KITITAS COUNTY

MEMORANDUM

TO: Community Development Services
FROM: Taylor Gustafson, Environmental/Transportation Planner
DATE: March 15, 2019
SUBJECT: Carlson Farms BL-19-00003

In review of the Preliminary Survey, Public Works has the following comments:

PART OF THE SOUTHWEST QUARTER OF SECTION 7,
TOWNSHIP 18 NORTH, RANGE 19 EAST, W.M.

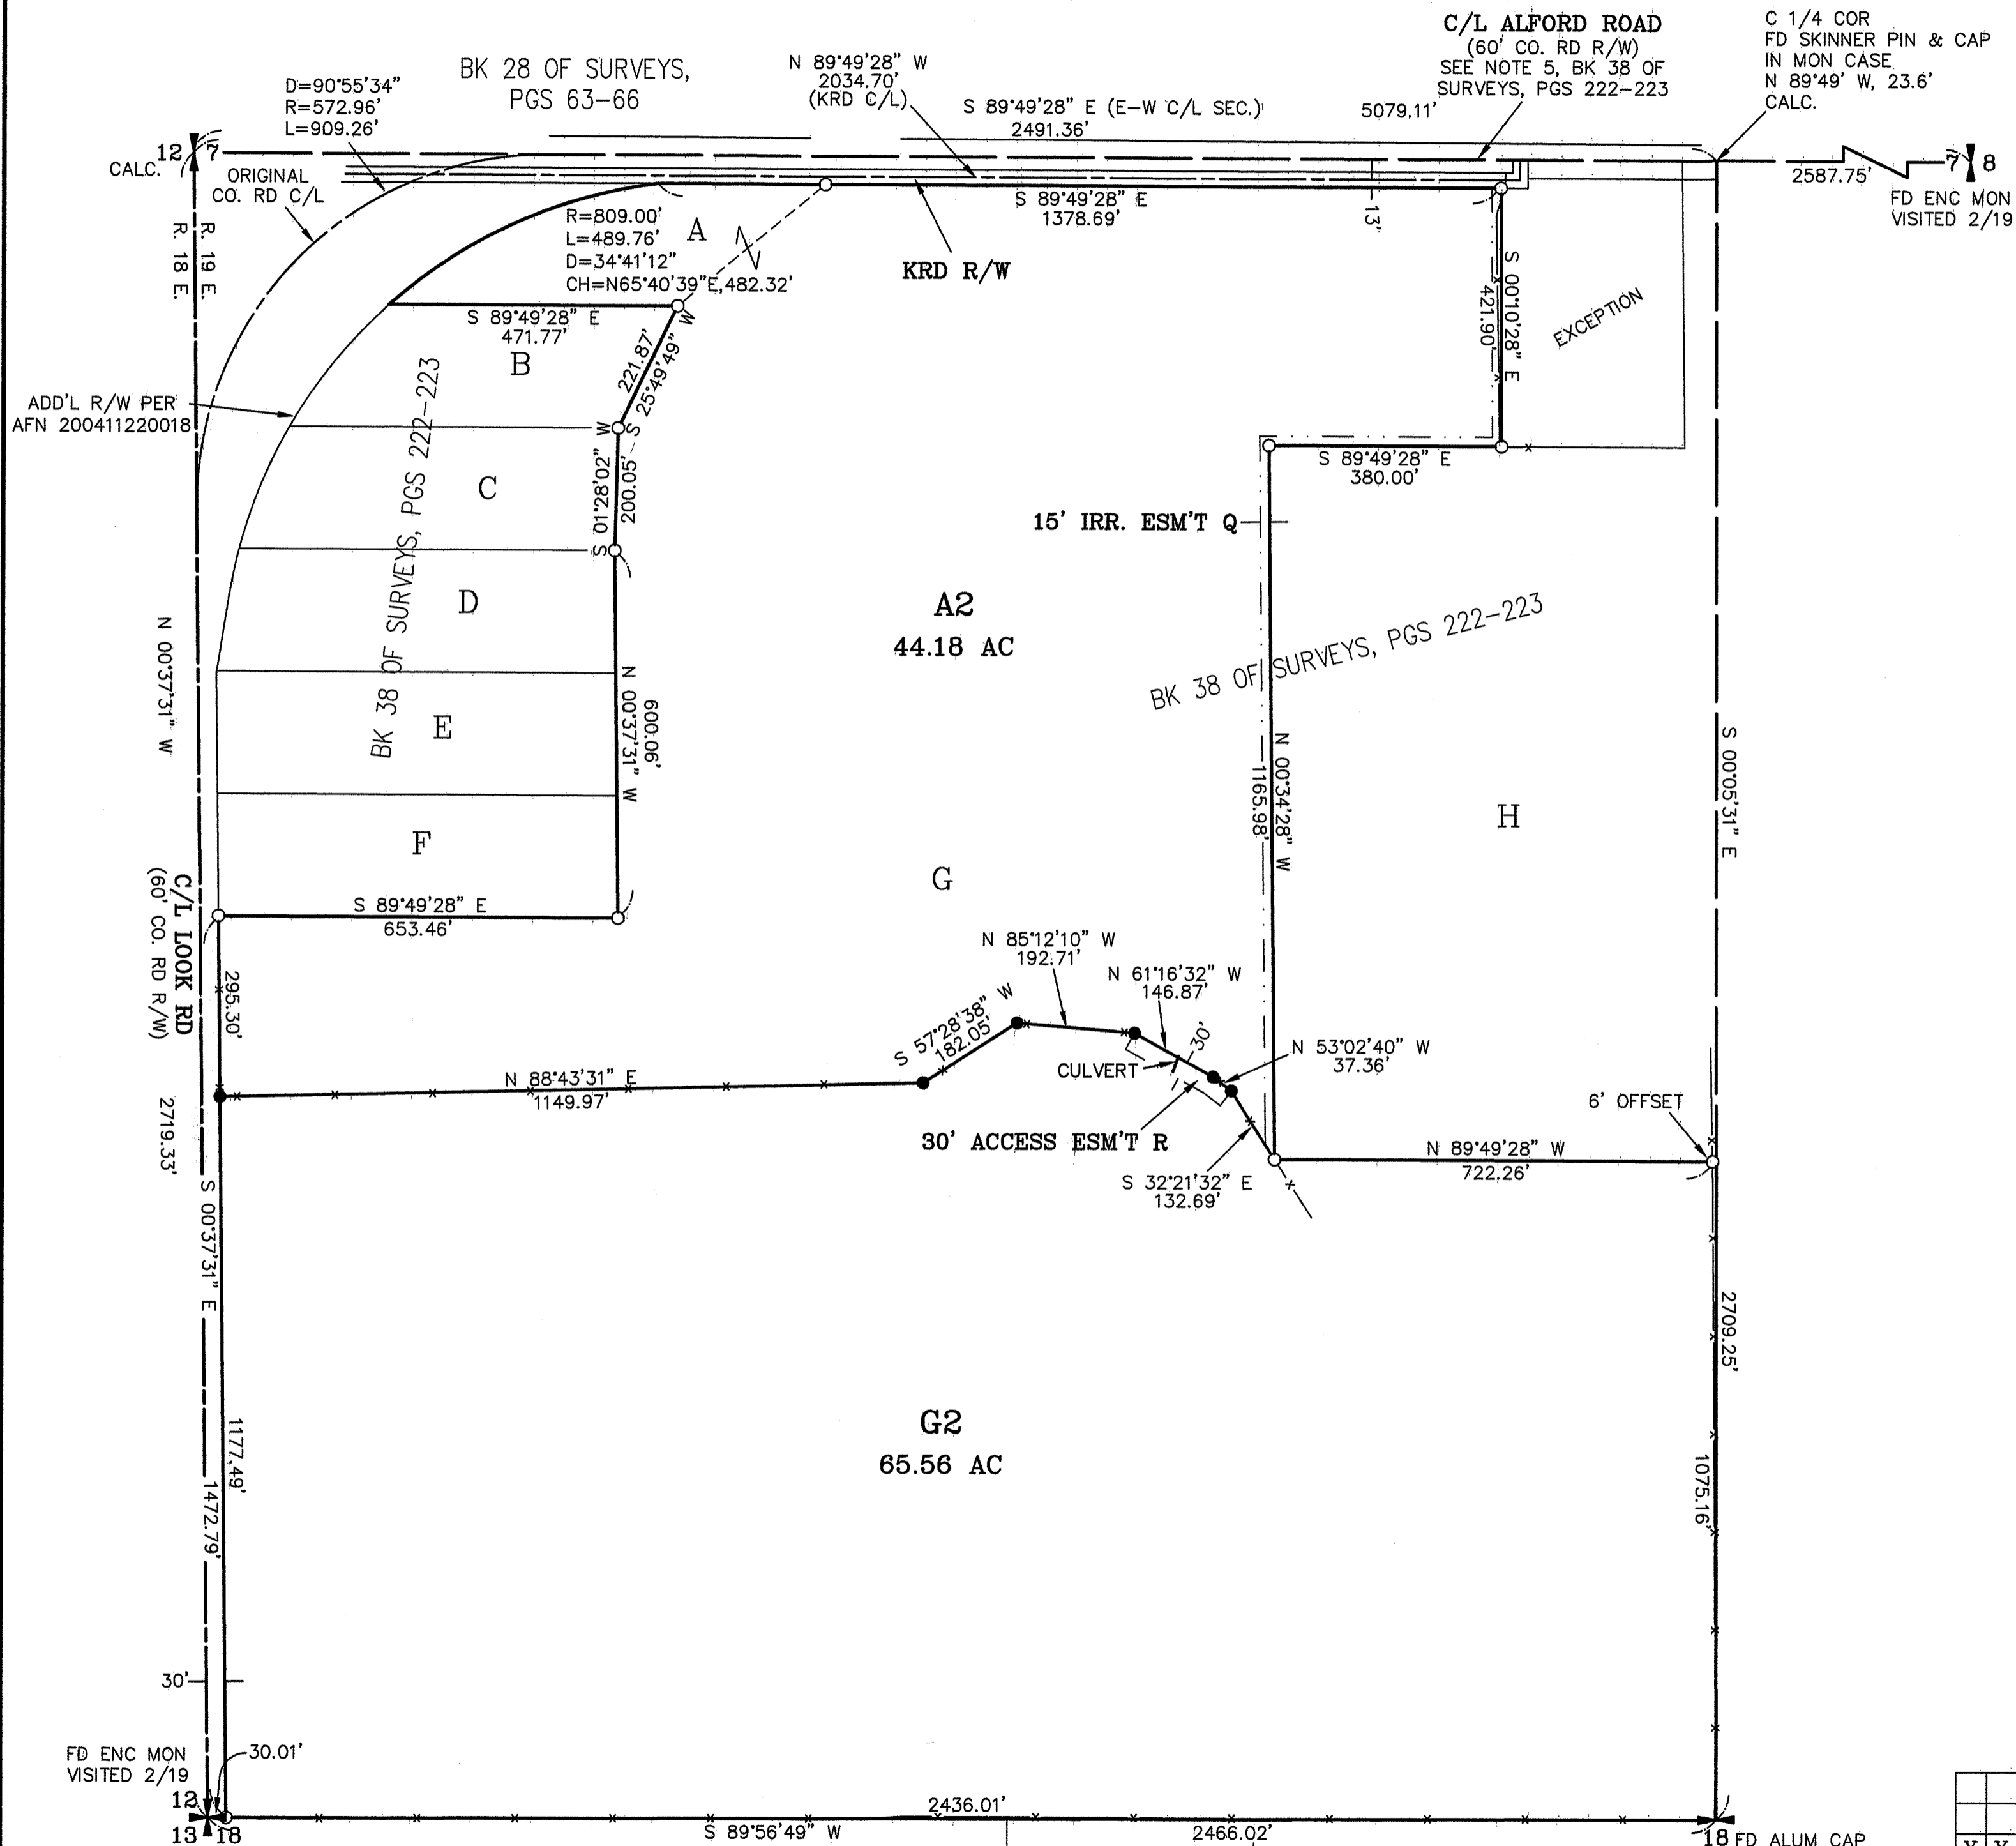
1. Label the proposed new boundary between Parcels A2 and G2.
